From: Nicola Oktay on behalf of Planning.Responses
Sent: 03 February 2025 09:57
To: Planning Scanning
Subject: FW: WSCC Consultation Response from County Highways - Planning Services - A/222/24/PL
Importance: High

From: Emma Avis <[REDACTED]>
Sent: 30 January 2025 14:26
To: Planning <Planning@arun.gov.uk>
Cc: Deborah Urquhart <[REDACTED]>
Subject: WSCC Consultation Response from County Highways - Planning Services - A/222/24/PL
Importance: High

TO:	Arun District Council (ADC) - The Local Planning Authority (LPA) Planning officer: Mr S Davis
CC:	Cllr Deborah Urquhart
FROM:	West Sussex County Council (WSCC) – The Local Highway Authority (LHA) - Consultee to the LPA Planning officer: Emma Avis
LOCATION:	Sports Pavilion, Decoy Drive, Angmering, BN16 4DN
SUBJECT:	A/222/24/PL - Demolition of existing pavilion; erection of new Sports and Community Hub comprising of new 3G football pitch, improved turf pitches for football, multi-use games area, locally equipped play area, hub building, storage facility, car parking, EV charging points, access road, landscaping, associated works and infrastructure. This application is a Departure from the Development Plan and is in CIL Zone 3 (Zero Rated

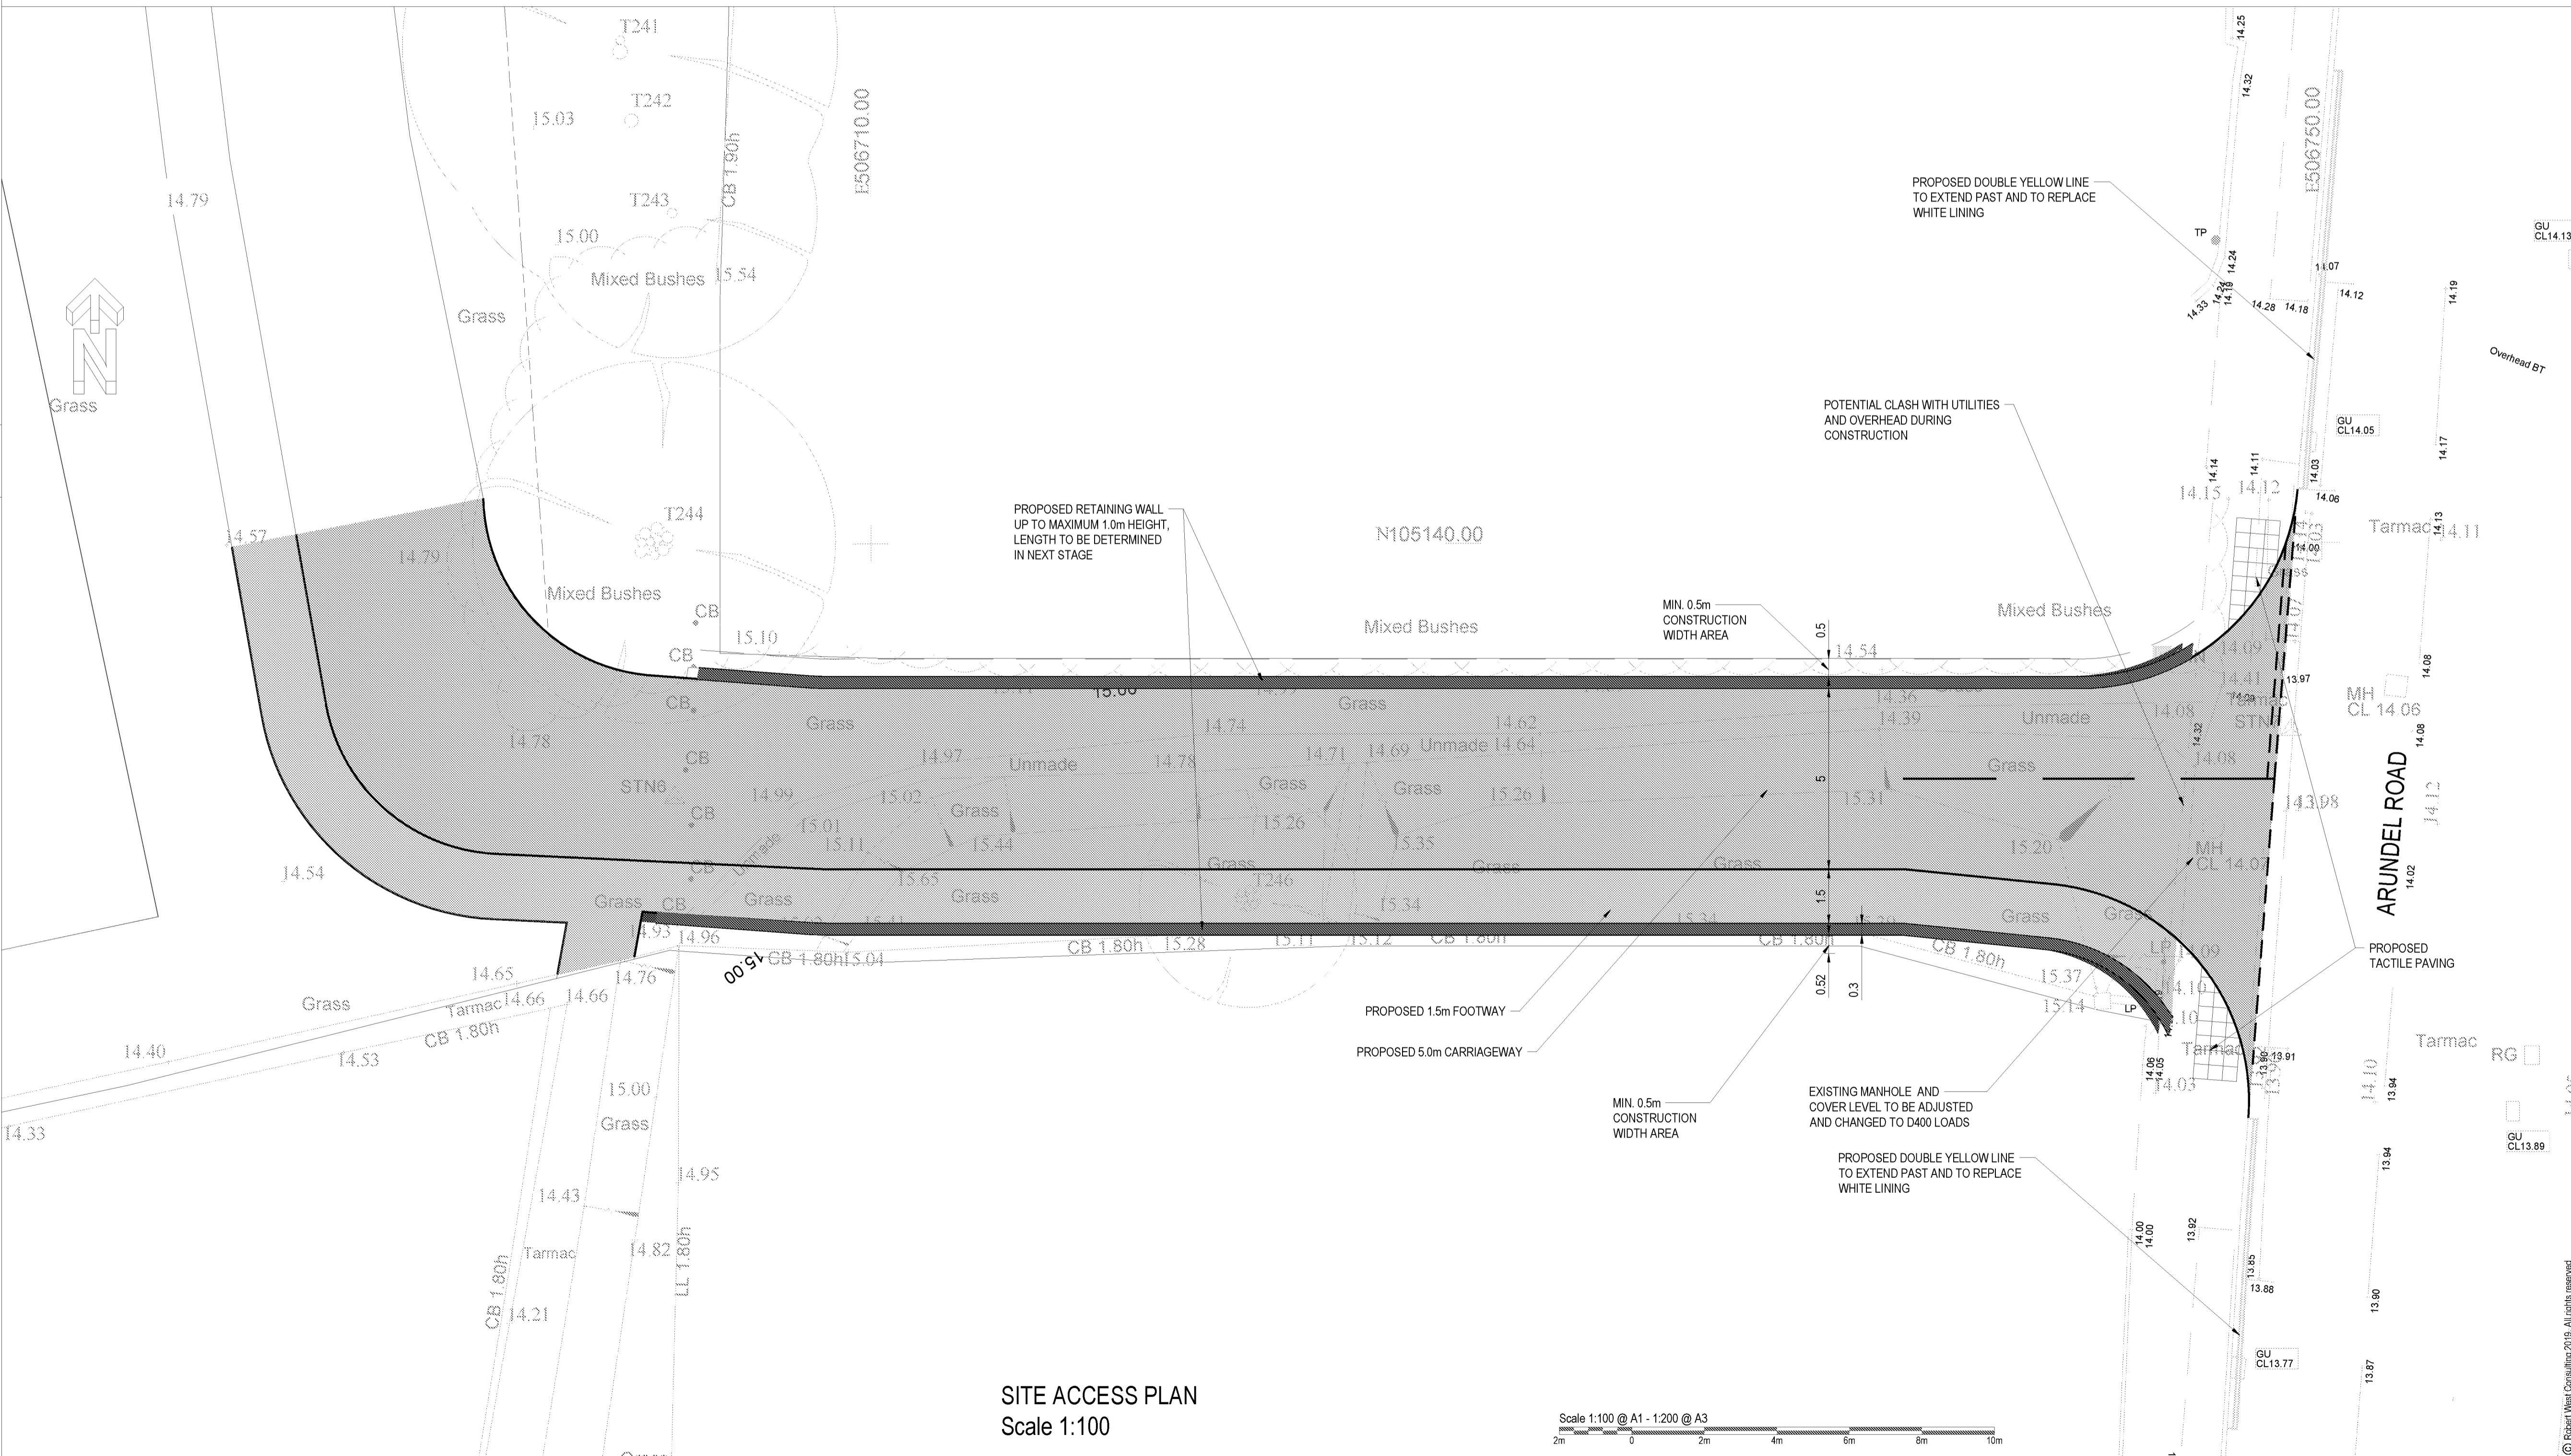
2.2 A Stage 1 Road Safety Audit (RSA) has been carried out on the access design, this included a site visit to the site by the two safety auditors. One problem has been raised in the safety audit, this is about the access and its visibility splays. The auditor has raised the matter of on street parking affecting visibility at the junction out onto Arundel Road. The auditors have recommended that a Traffic Regulation Order (TRO) is put in place to implement double yellow lines either side of the access to protect the junction from vehicles parking in the visibility splays.

The site access plan shows double yellow lines extending past the white H bar driveway markings on either side of the adjacent properties. It is likely that this will displace around 4 on street parking spaces, if the TRO is approved. The applicant must be aware that the TRO consultation/approval process is a completely separate application and process to a planning application via the WSCC TRO team.

In terms of the double yellow lines the LHA would expect them to follow the access and follow the curve round into the site access. We would also question the extent of them, do they need to extend further than the end of the adjacent dwellings white H bar driveway markings? Manual for Streets 2 (MfS2) highlights how some obstruction to visibility, especially in built up areas can actually be beneficial to reducing entry and exit speeds at junctions, while encouraging drivers to proceed with more caution. In some situations providing more visibility can actually increase road speeds, increasing the risk and severity of a collision. By reducing the double yellow lines on either side of the access it would mean the loss of only 2 on street parking spaces, while still providing protection for the junction.

2.3 The LHA would require a new site access plan provided that details the full extent of the double yellow lines and the secured signalised crossing, so we can assess the site access alongside the crossing. This plan also needs to be run past the RSA team, revised RSA comments are required and a complaint GG 119 RSA Response Report, then the LHA can review and complete the access review and RSA process.
